Gatwick Northern Runway

TR020005

National Highways Comments on any Submissions Received by Deadline 3

May 2024

Project Code-Location-Discipline-Volume-Type-Unique Number
41700- XX -B -LLO - GA - 200175

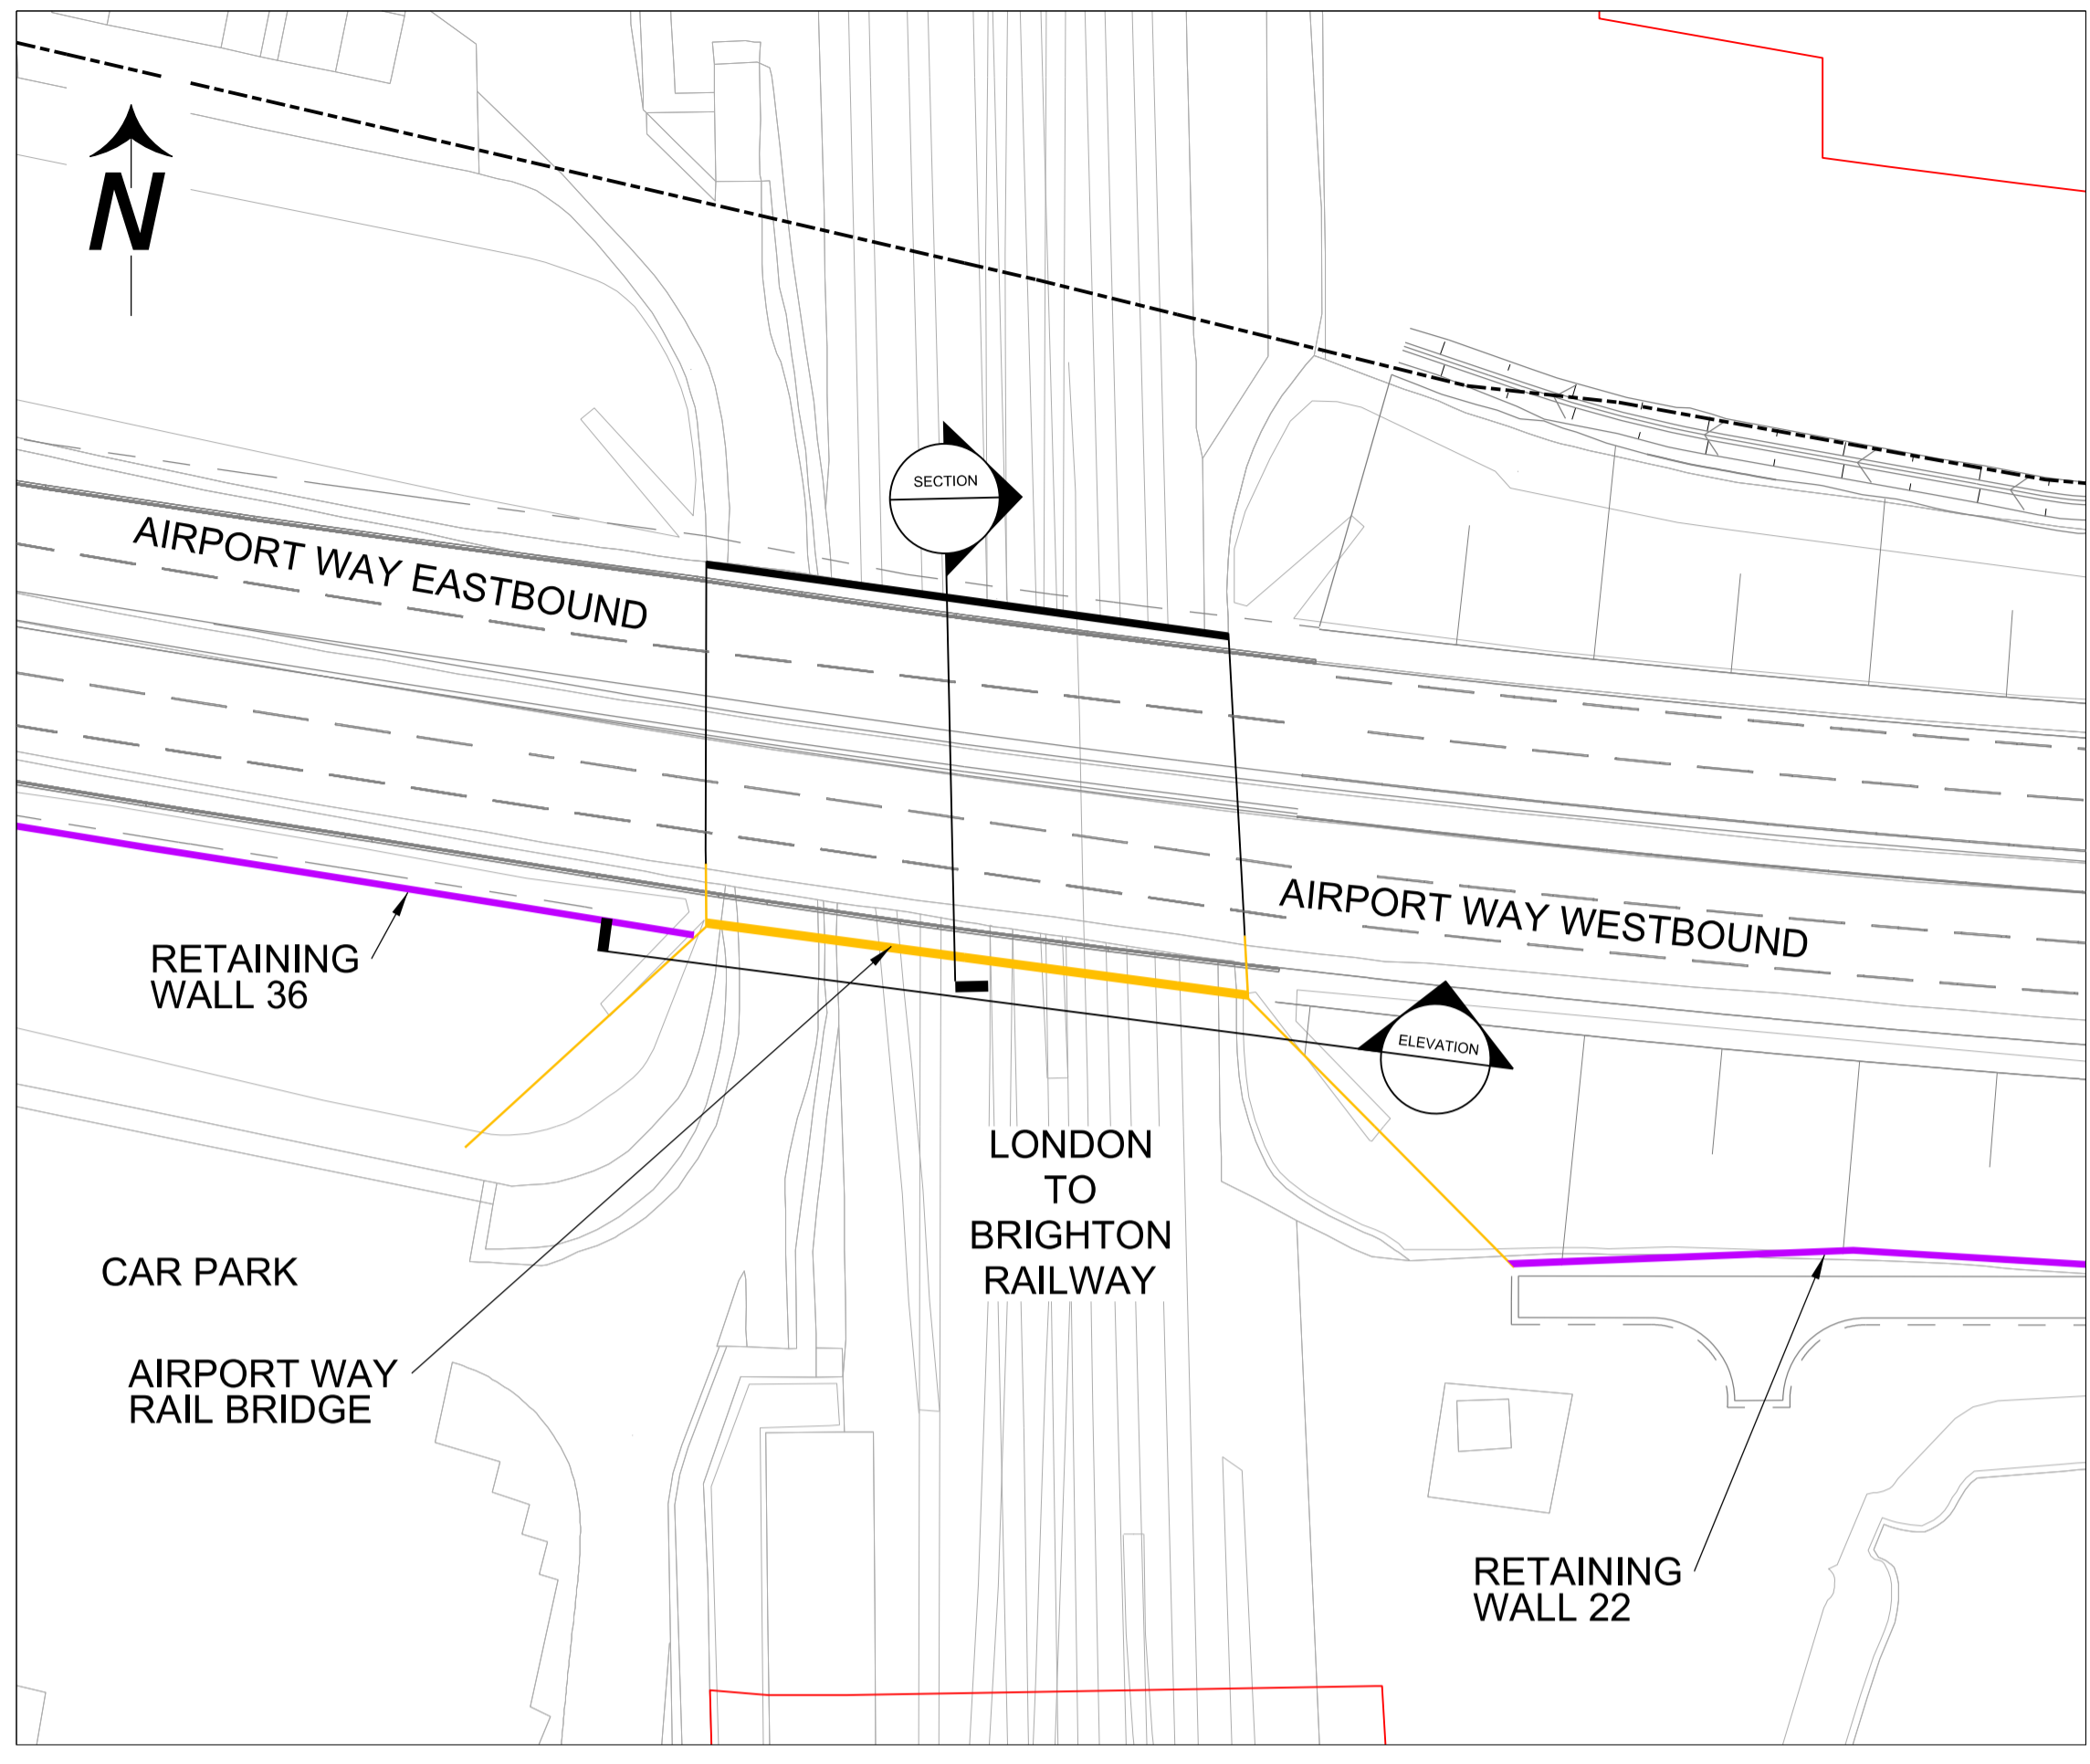
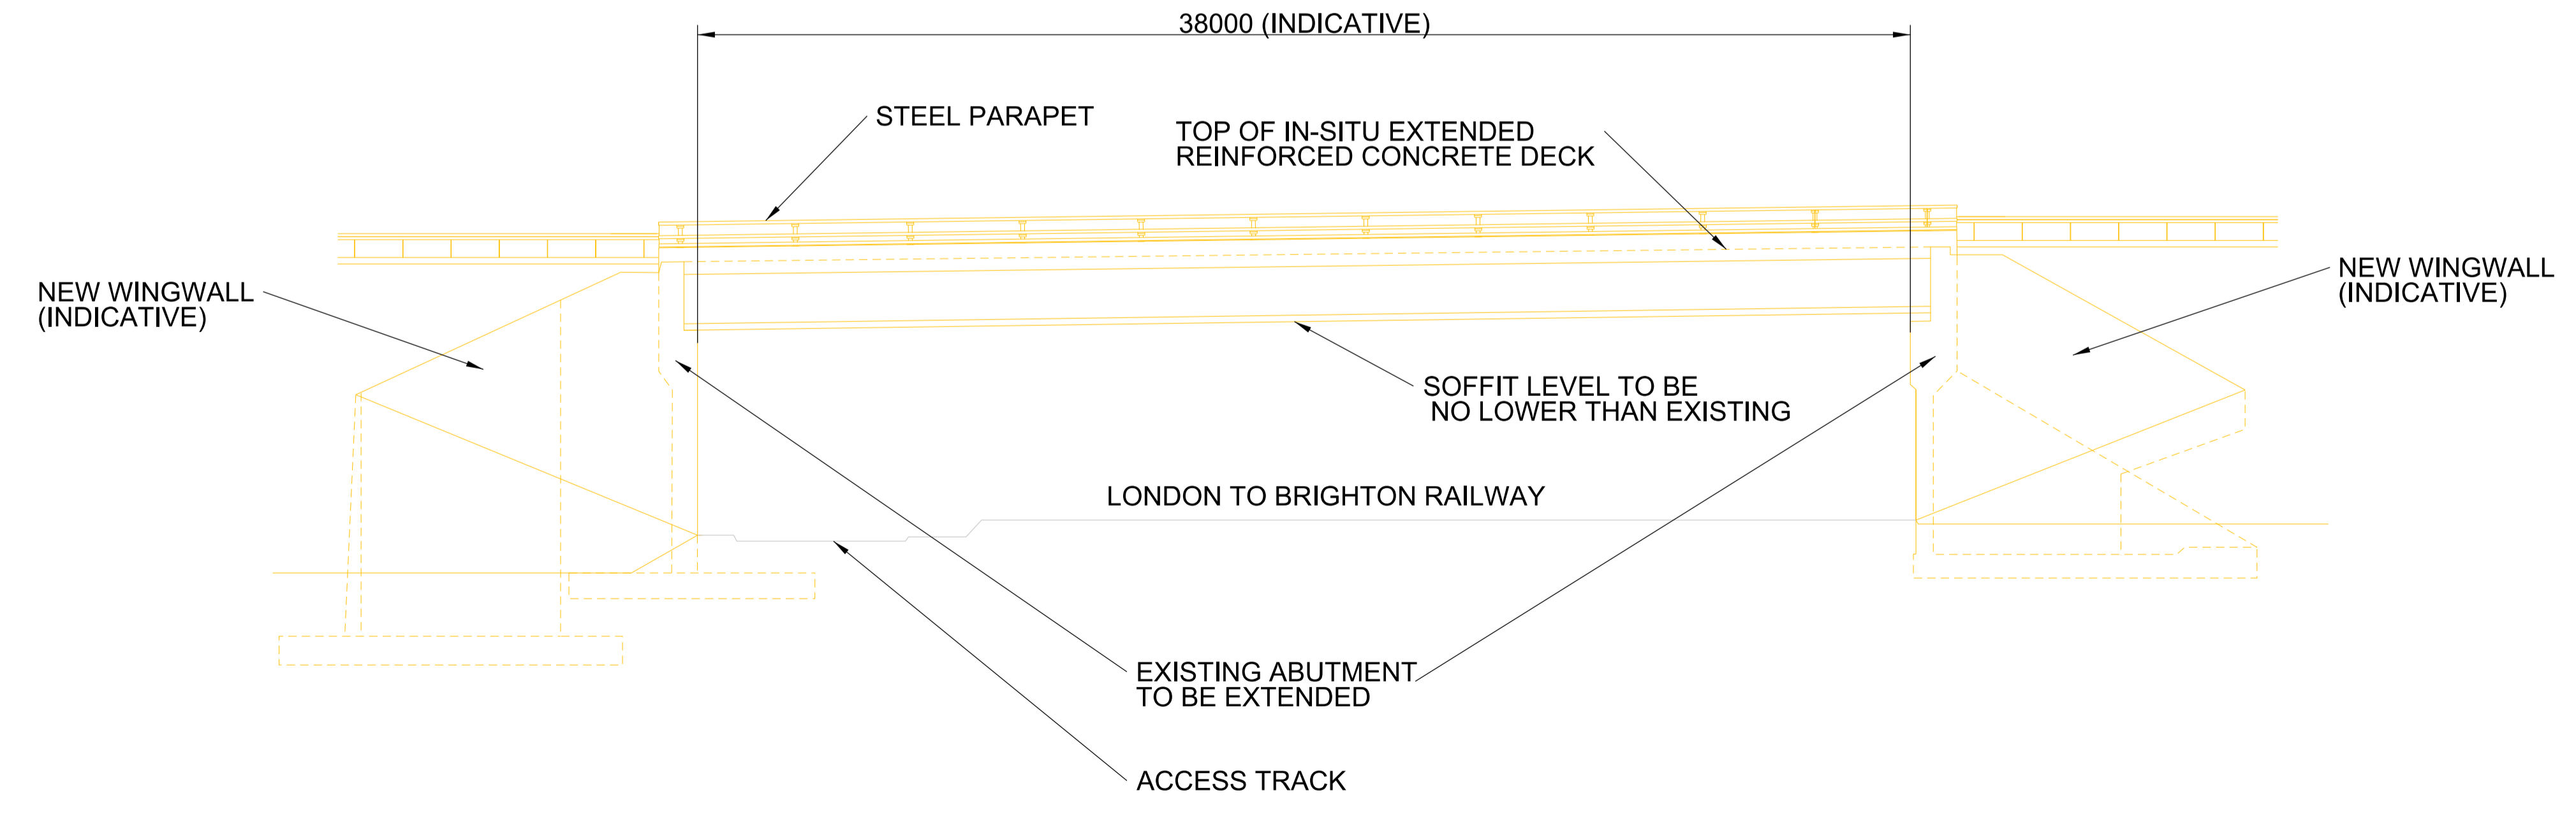
4.8.3 Surface Access Highways Plans – Structure Section Drawings – For Approval - Version 3 [TR020005/REP3/014]			
General	REP3-014	<p>Drawings:</p> <p>41700-XX-B-LLO-GA-200175 41700-XX-B-LLO-GA-200178</p>	<p>National Highways notes that the Applicant has updated the cross section of Drawing 41700-XX-B-LLO-GA-200175 in order to amend the carriageway cross section to show a carriageway width of 7.3m which is in compliance with DMRB CD127 Cross Sections and Headroom.</p> <p>As part of this update to the package however, the Applicant has not considered the updated position that National Highways outlined in its Deadline 2 update to the Principal Areas of Disagreement Summary Statement [TR020005/REP2/059] which articulated the following in respect to cross sections where environmental barriers interface with structures:</p> <p><i>National Highways has reviewed the proposals by the Applicant and recommends the Applicant considers the following two options:</i></p> <p><i>If maintenance activities require operatives to access to the rear of the noise barrier, a pedestrian parapet system is to be installed on the structure to act as an edge restraint to minimise the risk of falling.</i></p> <p><i>If there are no maintenance activities required to the rear of the noise barrier, the noise barrier is to be repositioned on the structure to sit on the plinth, thereby restricting any unauthorised access to the structure. If this solution is considered by the Applicant, the relocation of the noise barrier may need to be considered as part of any acoustic assessments.</i></p>
